Pre-Design Investigation
(Additions)

DATE 11-9-82

ADDRESS _____ ZONE ATLAS # H-20

## FOUNDATION PLAN

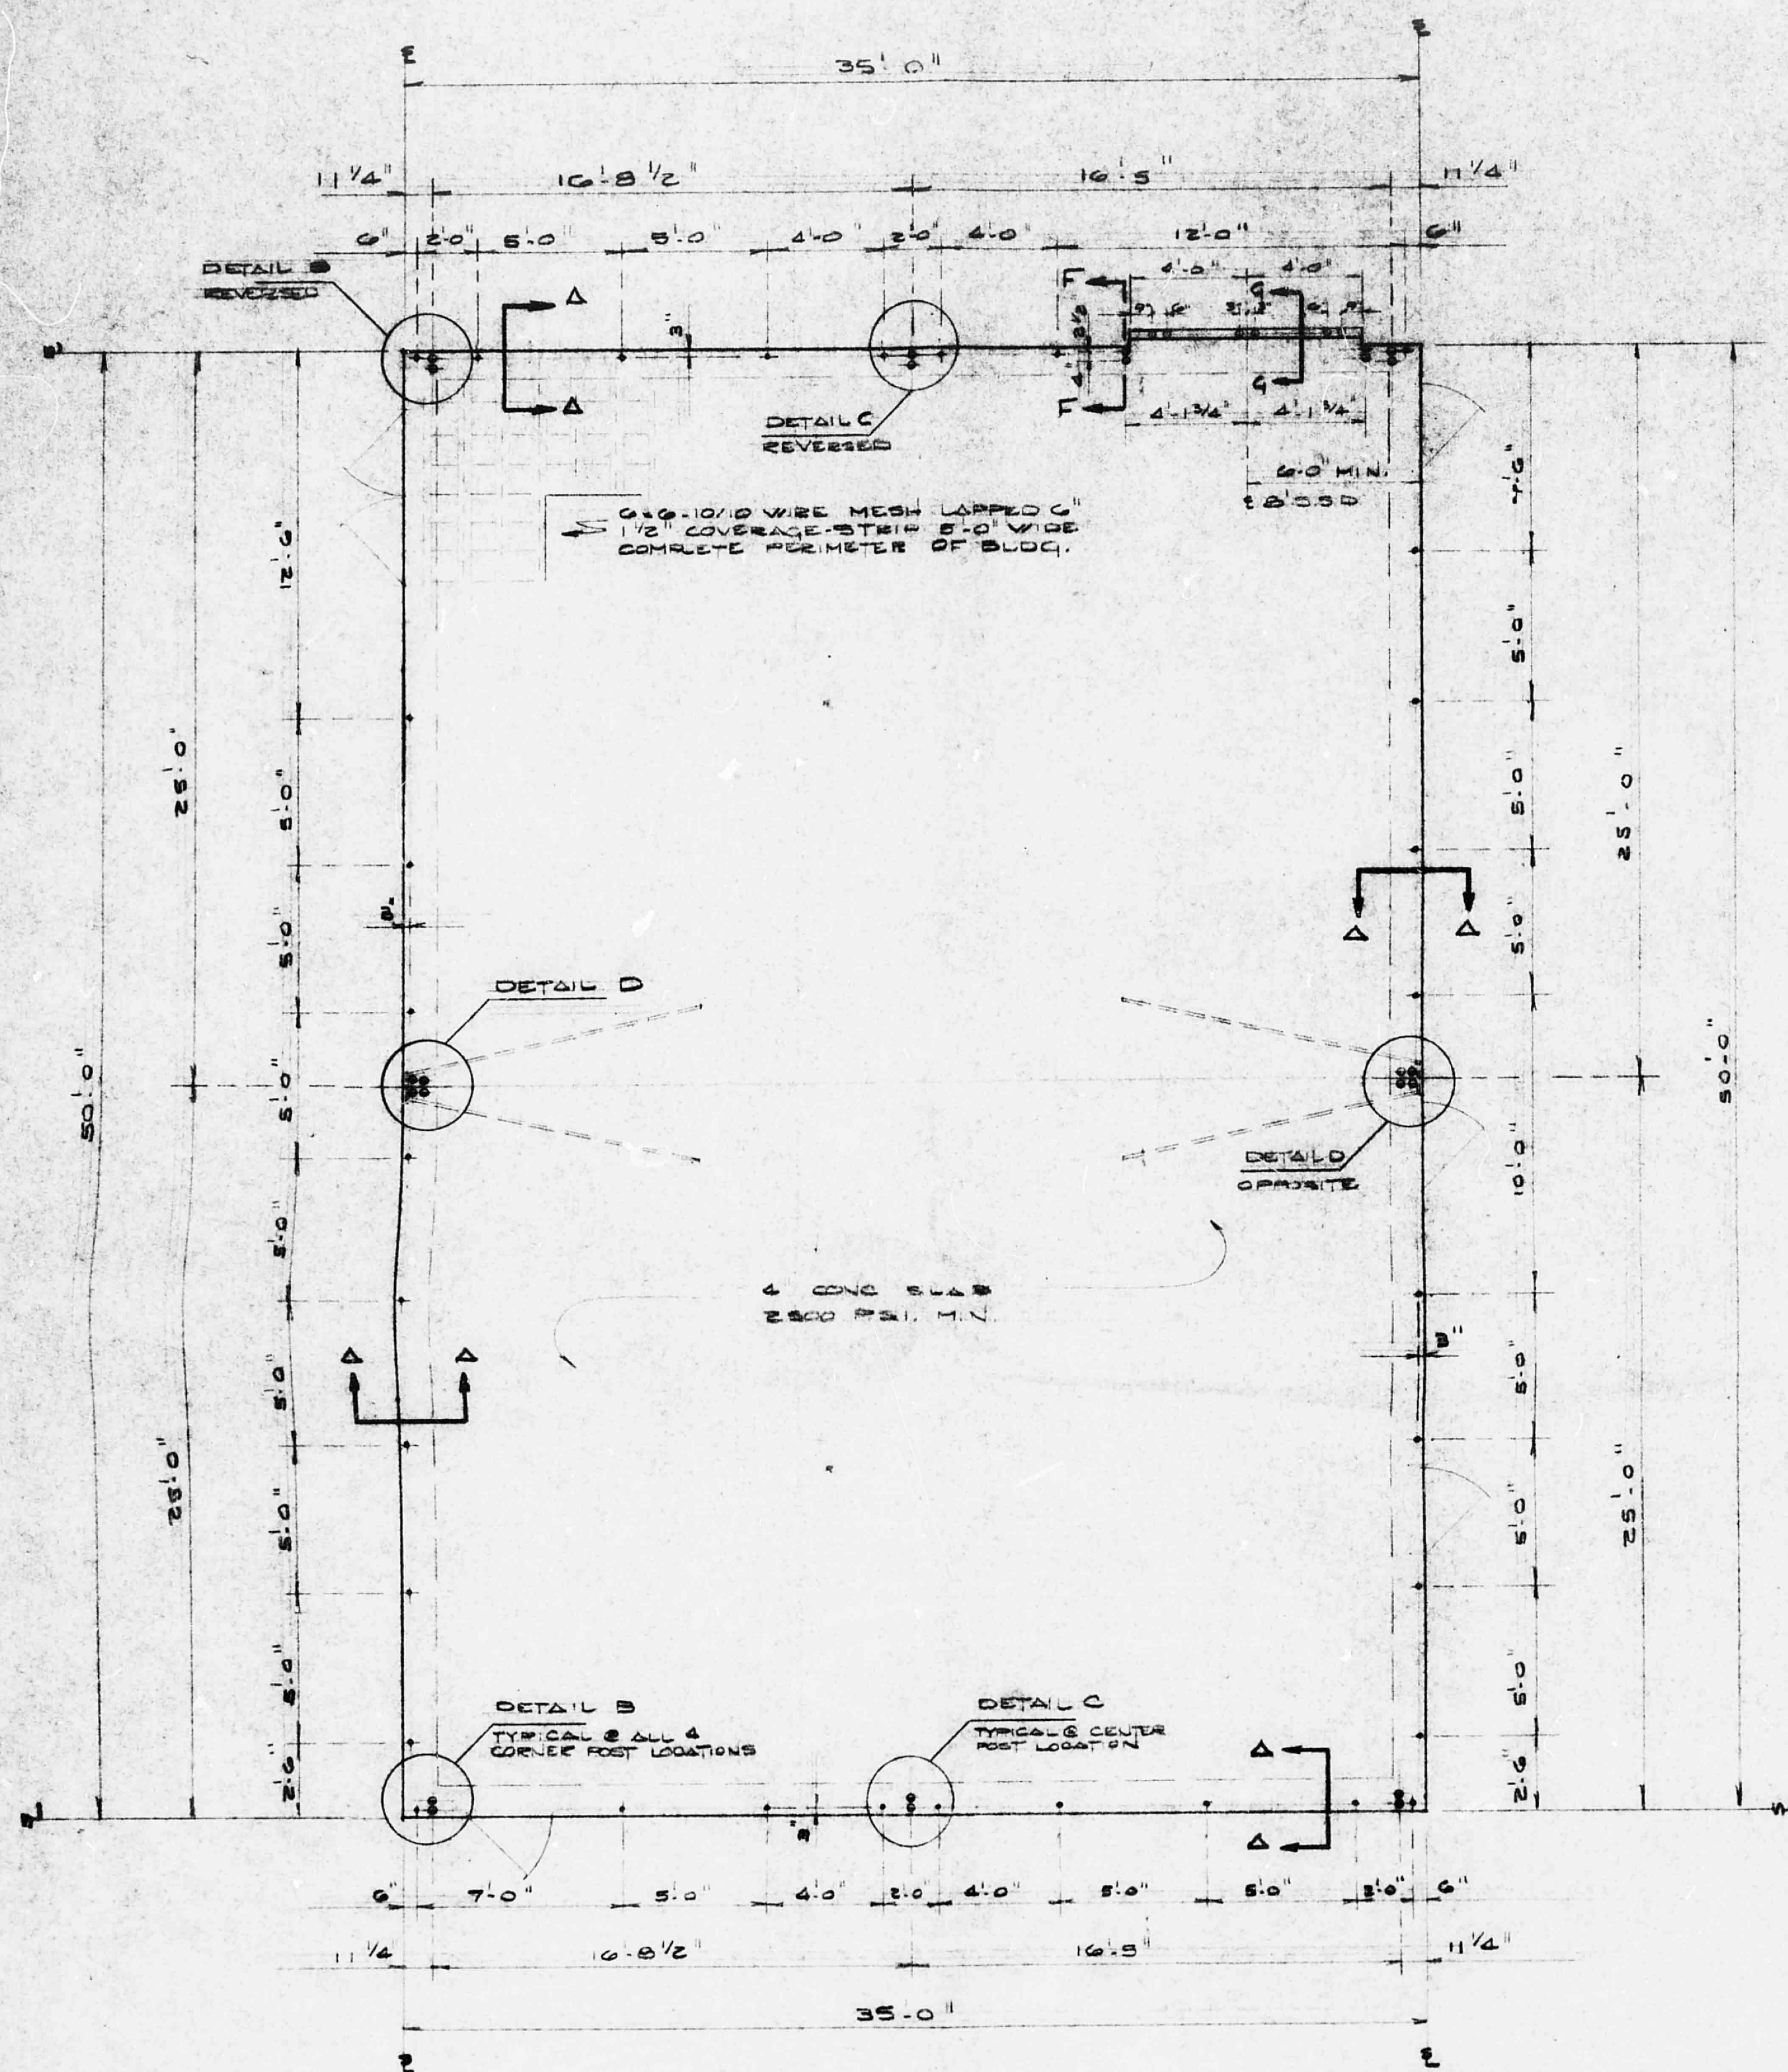
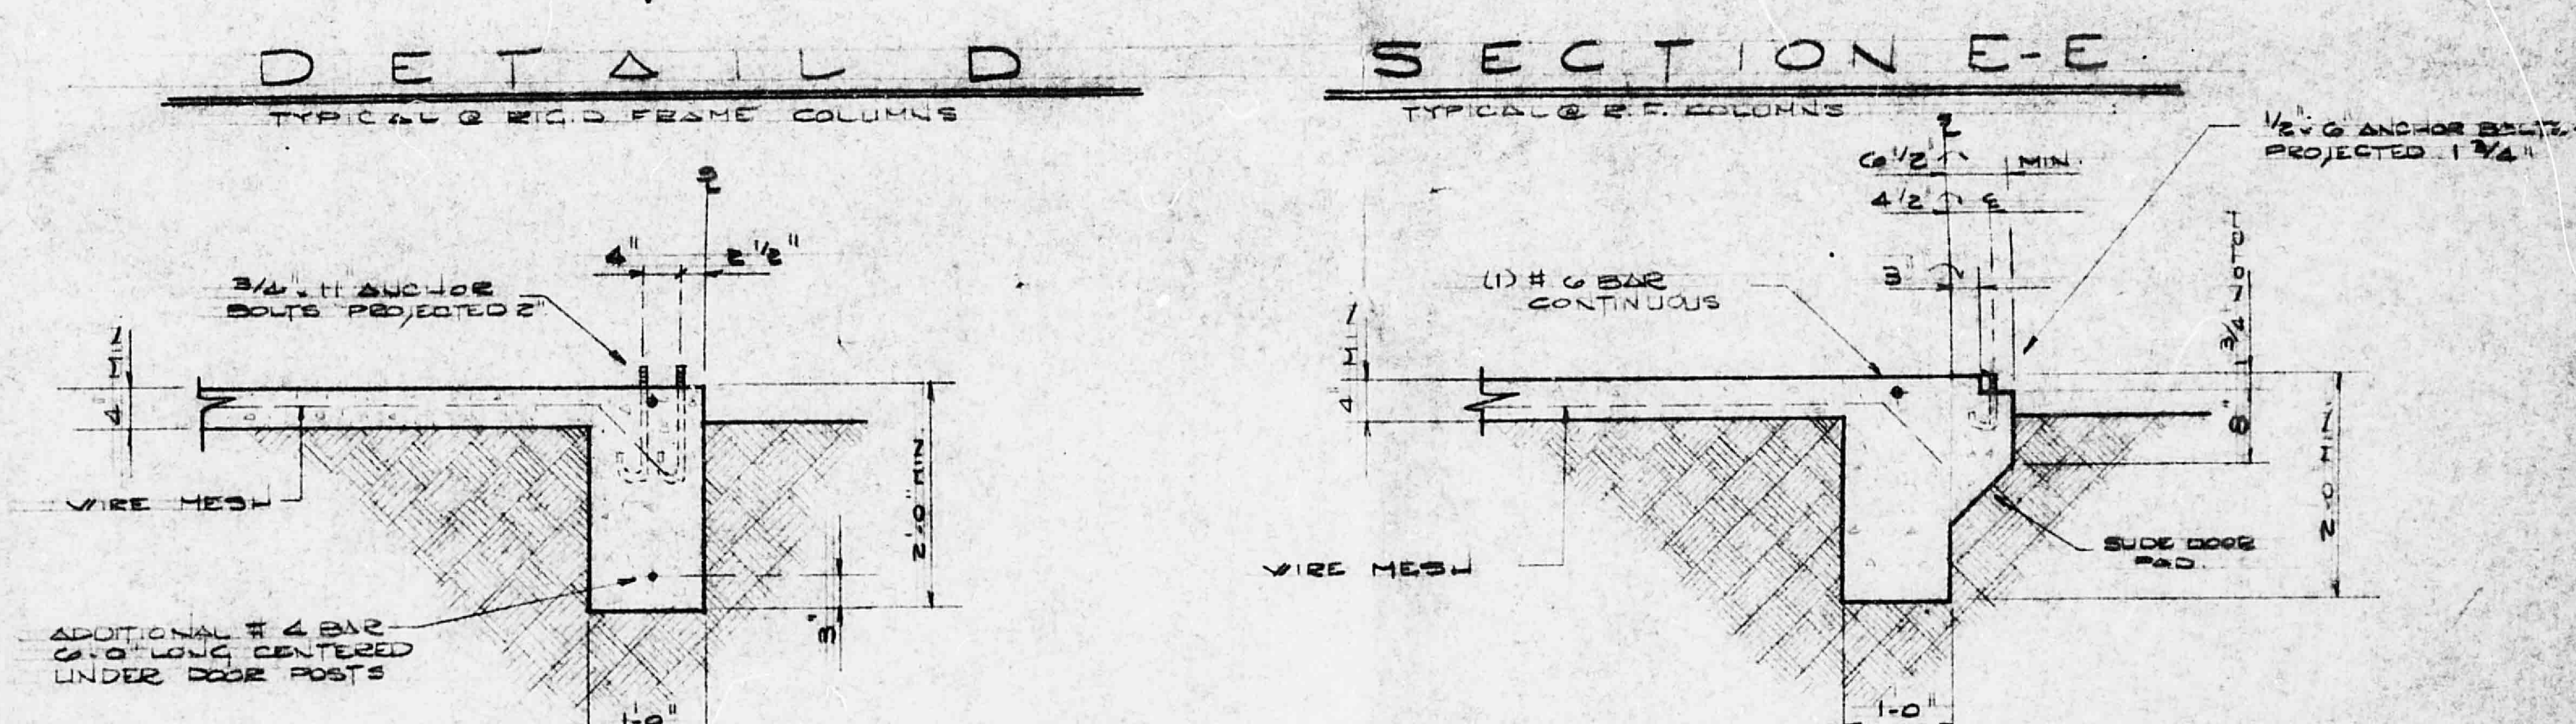
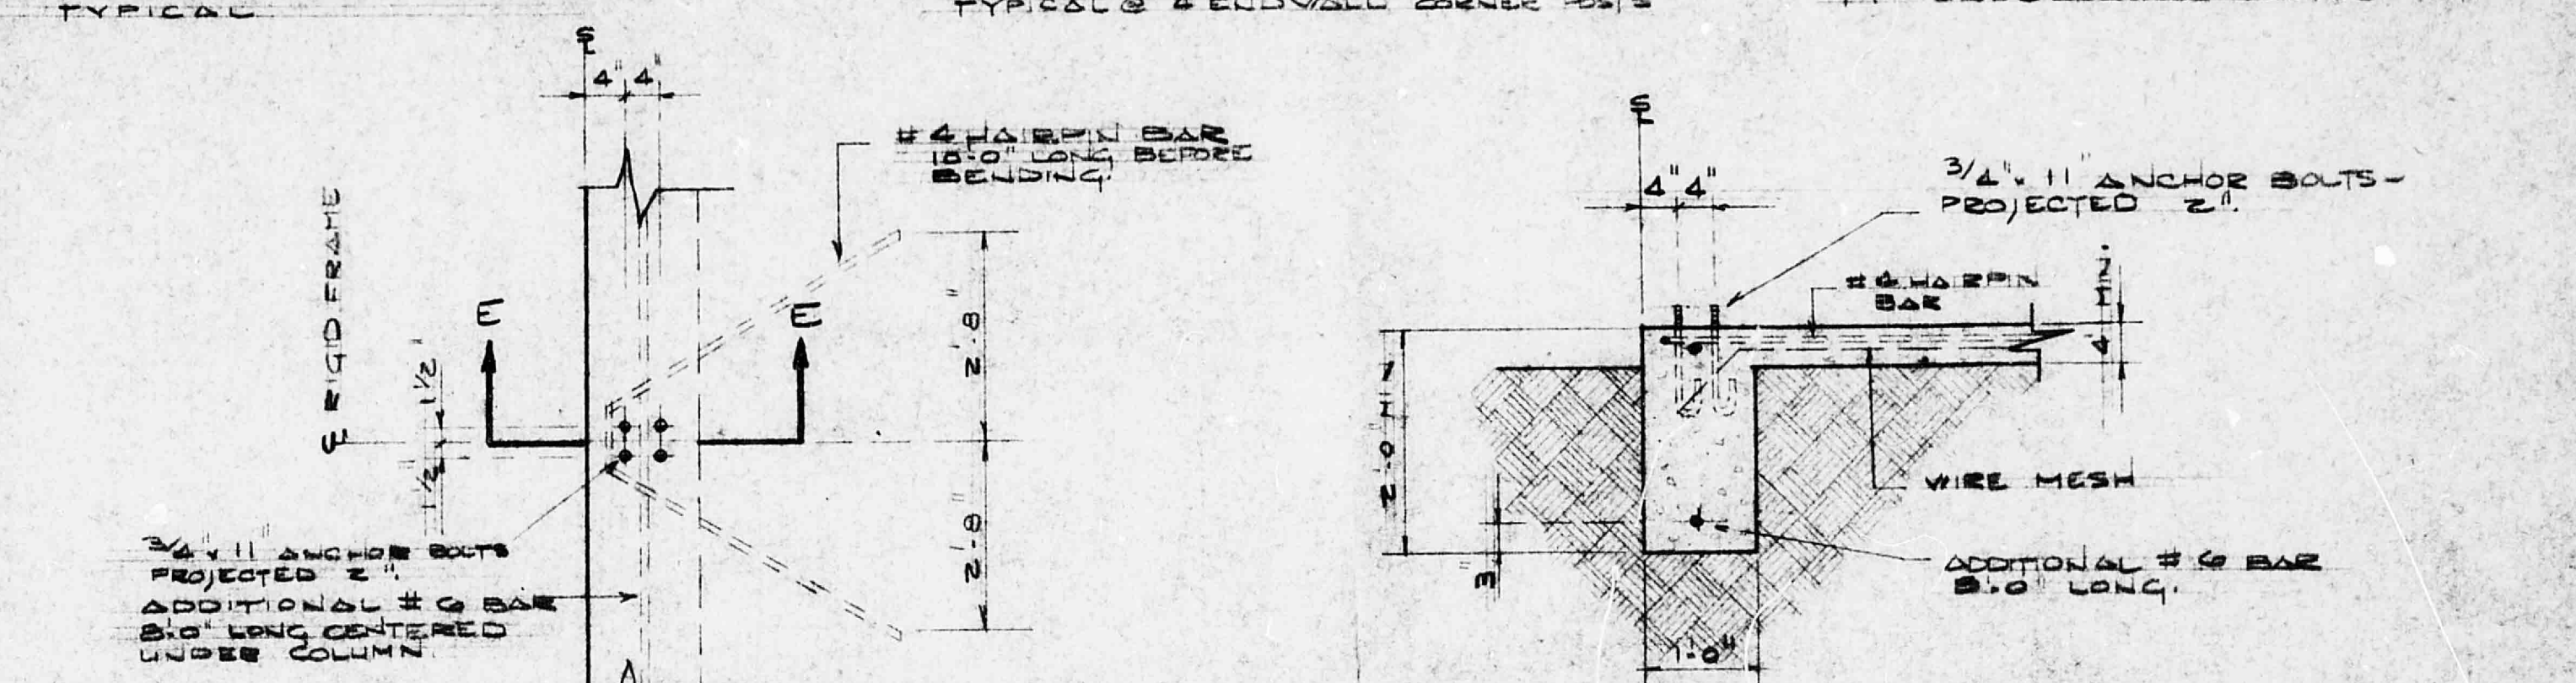
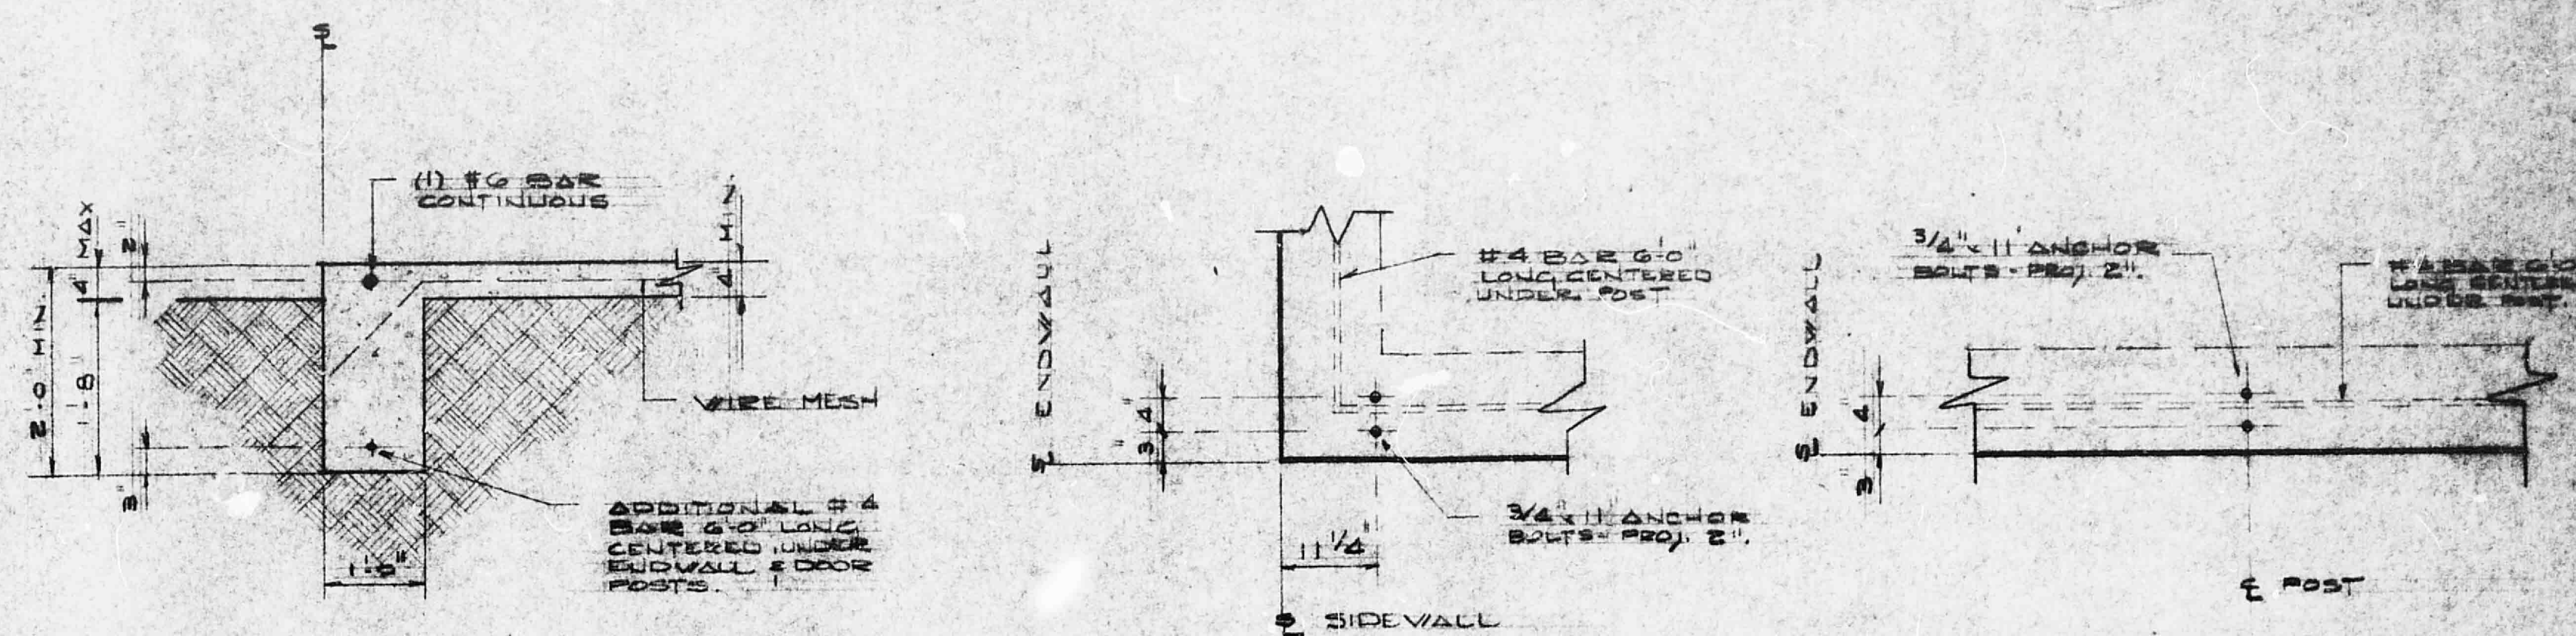
1. Finish Floor elevation, water from new building to be routed towards Eubank, show location of roof spouts and also show flow pattern of existing flows

11/3/82 Need T.B.M. to M.S.L. on site to build the foundation to the required elev. set by Mike Gribb.

Approval to be granted only for the Butler Building going in roof drains to be drained toward Eubank talked to Mike on 11-11-82
